Our Ref: 20048269  
PINS Ref: EN010119  
Date: 15 July 2025  
Telephone: [REDACTED]

**Planning Act 2008 – Application by North Falls Offshore Wind Farm Limited for an Order Granting Development Consent for the North Falls Offshore Windfarm (EN010119)**

I refer to the Rule 8 letter dated 4 February 2025 which sets out the Examination Timetable for the above Development Consent Order (DCO), currently at Examination. Essex County Council (ECC) in conjunction with Tendring District Council (TDC), and as described as The Councils, would like to provide a written response to the Applicant's submission at Deadline 06. Responses to ExQ3 are submitted separately.

Chart 1: Example Flowchart

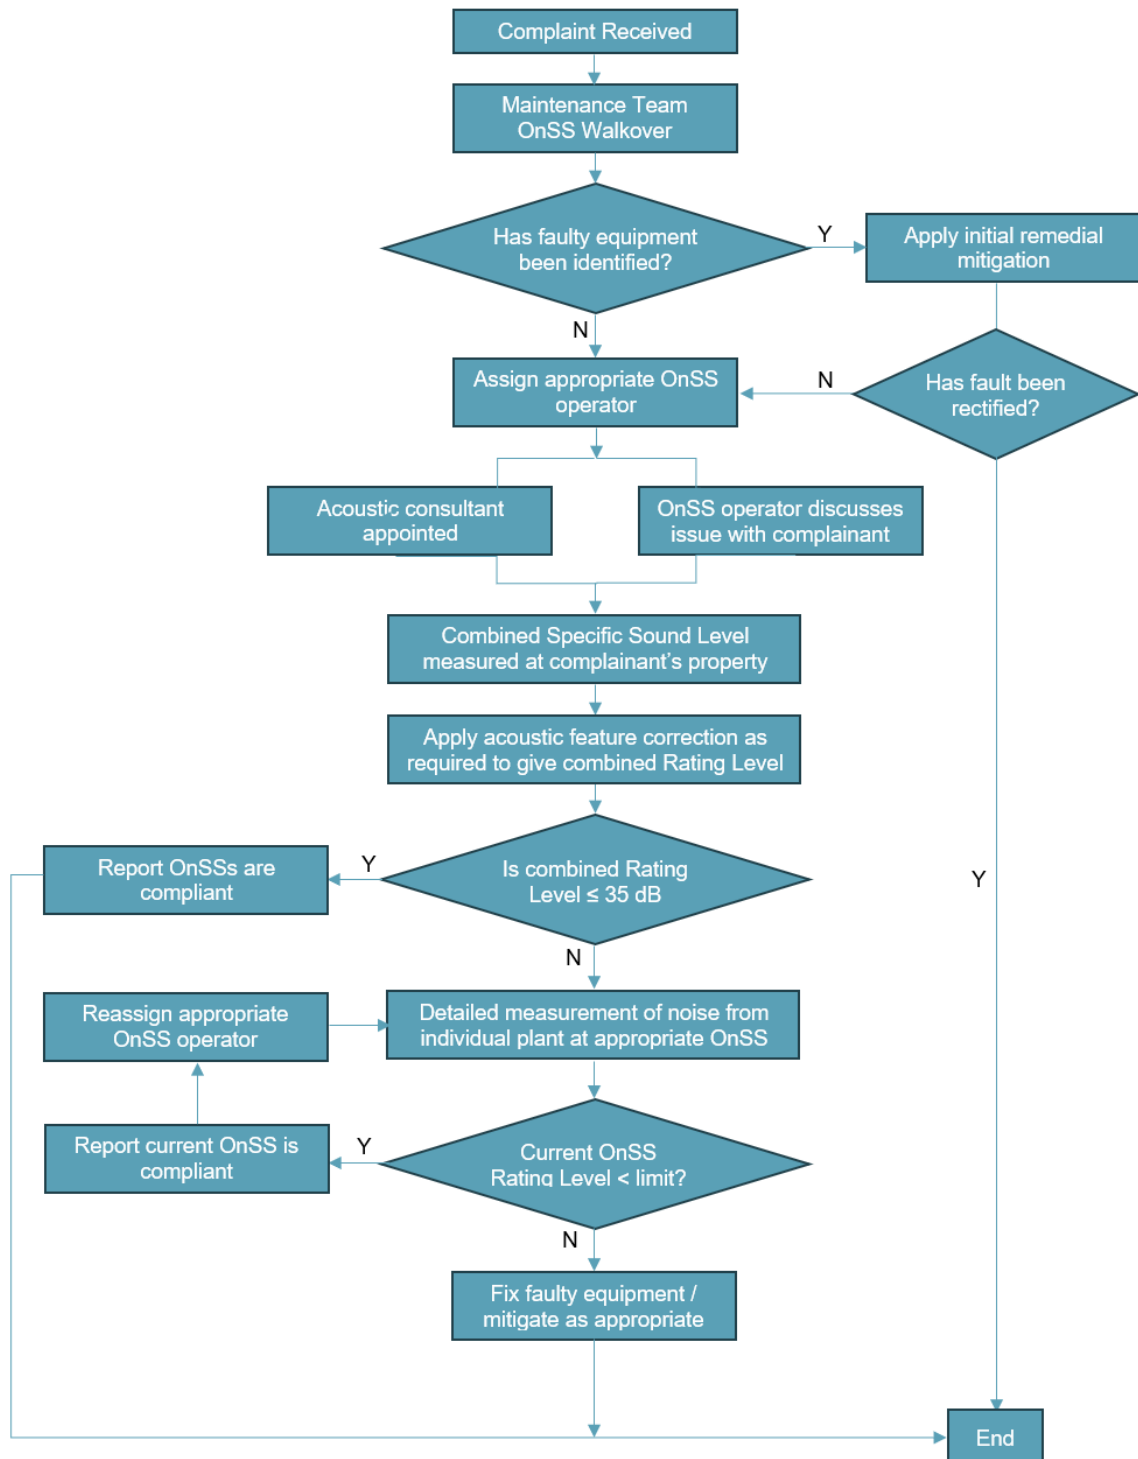
The applicant has not addressed the Councils’ concerns raised at the Issues Specific Hearing (REP4-072) and Deadline 4 (REP4-073) that the protocol lacks a Joint Noise Panel to collectively deal with the potential cumulative noise impacts. The current approach proposed by the applicant is fragmented and down to individual operator to investigate any noise complaints, without considering that there could be a scenario that more than 1 operator(s) may also contribute to the noise issues, and the potential for all operators to act as swiftly as possible once complaint is received. This fragmented approach acts against the concept highlighted in the Co-ordination Report (REP1-005) and affirmed the piecemeal nature of these NSIPs, which have been repeatedly raised as a significant matter by the Councils as well as by the local communities. It is considered that such piecemeal investigation approach is inadequate to address any cumulative operational impacts.

As there is no precedent case for collocation of so many substations in such close proximity and that cumulative impacts on the local residents could not be fully anticipated, the Councils strongly maintain the request that any noise complaints during operational stage are addressed by all three developers (Five Estuaries, North Falls & National Grid) concurrently. These projects are collocated and could be responsible for individual or cumulative noise breaches, this is a collective responsibility.

While the Councils welcomed the retention of an acoustic consultant following commencement of operation, there is no reason why the overall investigation timeframe could not be shorten as requested. Moreover, it is also important to ensure that any investigation approach should apply to the entire operational period of the substation (with an indicative design life of 30 years), which is far beyond the 18 months as suggested for the retention period.

<b>Applicant's proposal</b>	<b>Councils' proposal</b>
<b>Initial site walkaround</b>	2 working days reduced to 48 hours	48 hours
<b>Appointment of noise consultant</b>	10 workings days	5 workings days
<b>Noise measurement</b>	10 workings days	5 workings days
<b>Reporting to LPA</b>	15 to 20 workings days	10 workings days

As shown in the above table, the new insertions do not significantly shorten the proposed timeframe for complaints to be investigated, and it is still around 8.5 weeks for a recommended mitigation. This is wholly unacceptable for the length of time that the complainant has to endure the problem. The Councils consider that the timeframe must be reduced to ensure complaints are dealt with in an expedient manner.

1 New visualisation (VP9) from Barn Lane - Grange Road

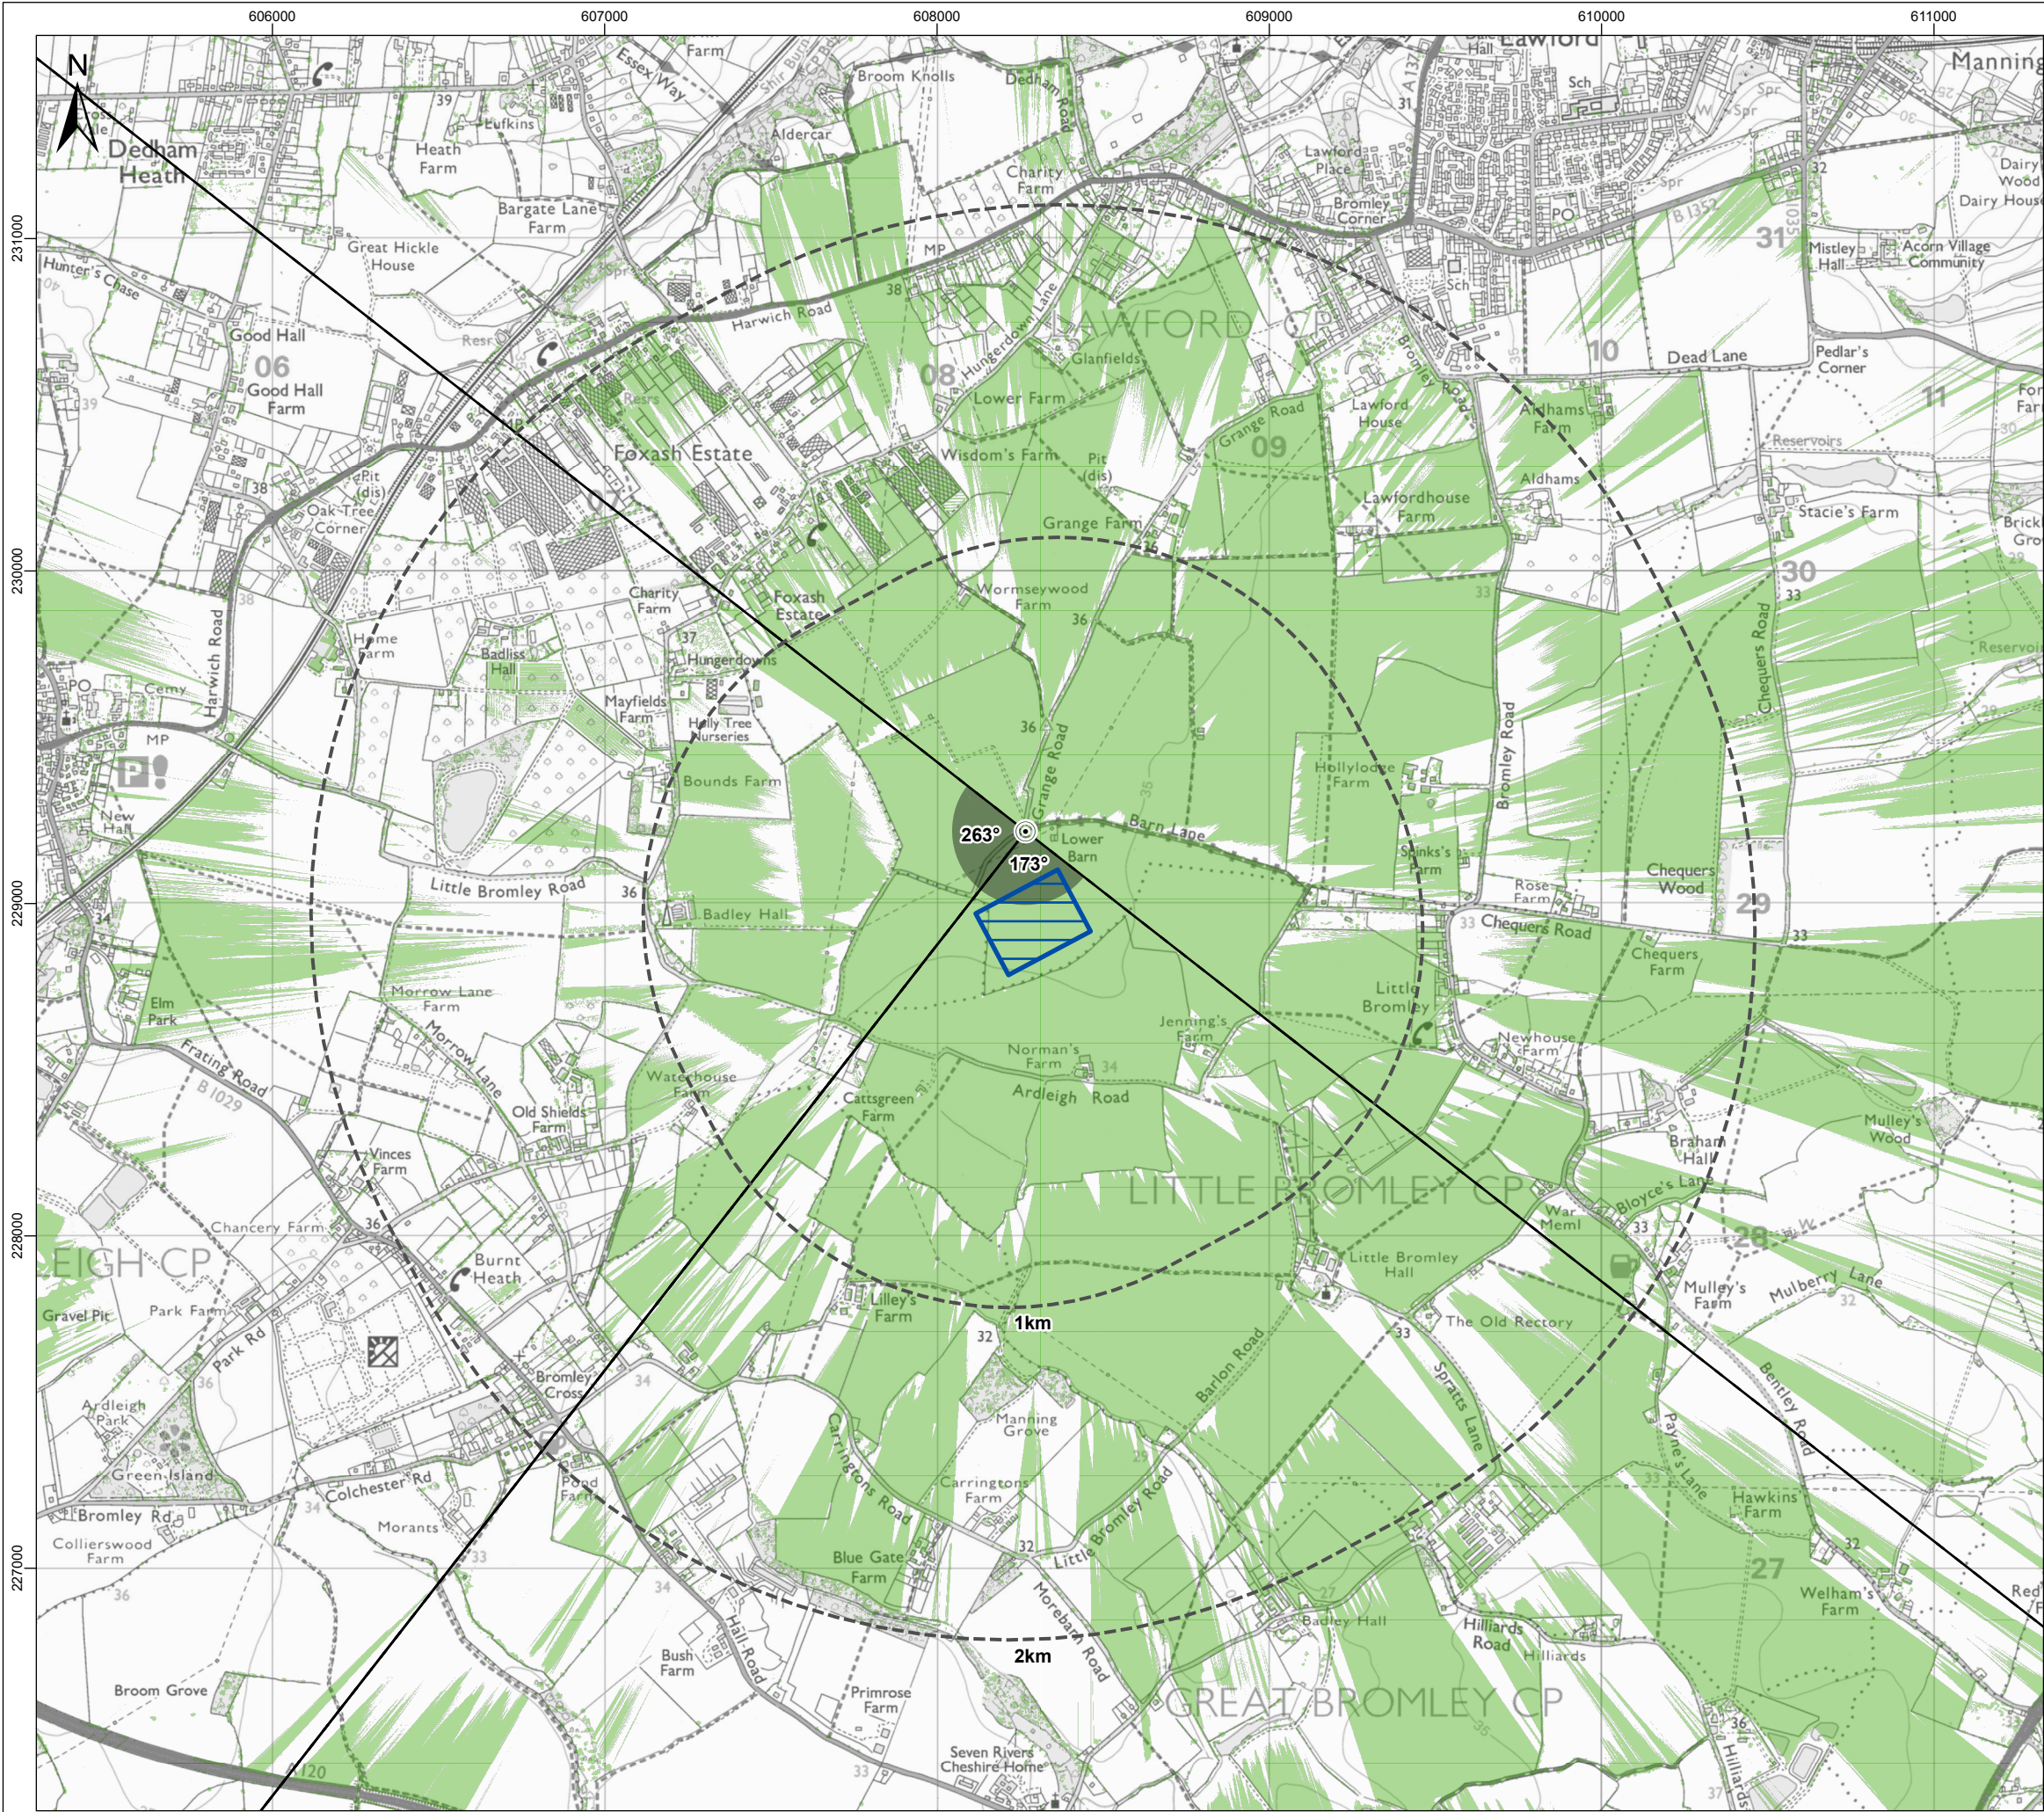
REP6-065 9.93 New visualisation (VP9) from Barn Lane - Grange Road Part 1 of 2 (Rev 0),  
REP6-066 9.93 New visualisation (VP9) from Barn Lane - Grange Road Part 2 of 2 (Rev 0)

Both new visualisations reinforce the previous position that screening will be necessary along the byway.
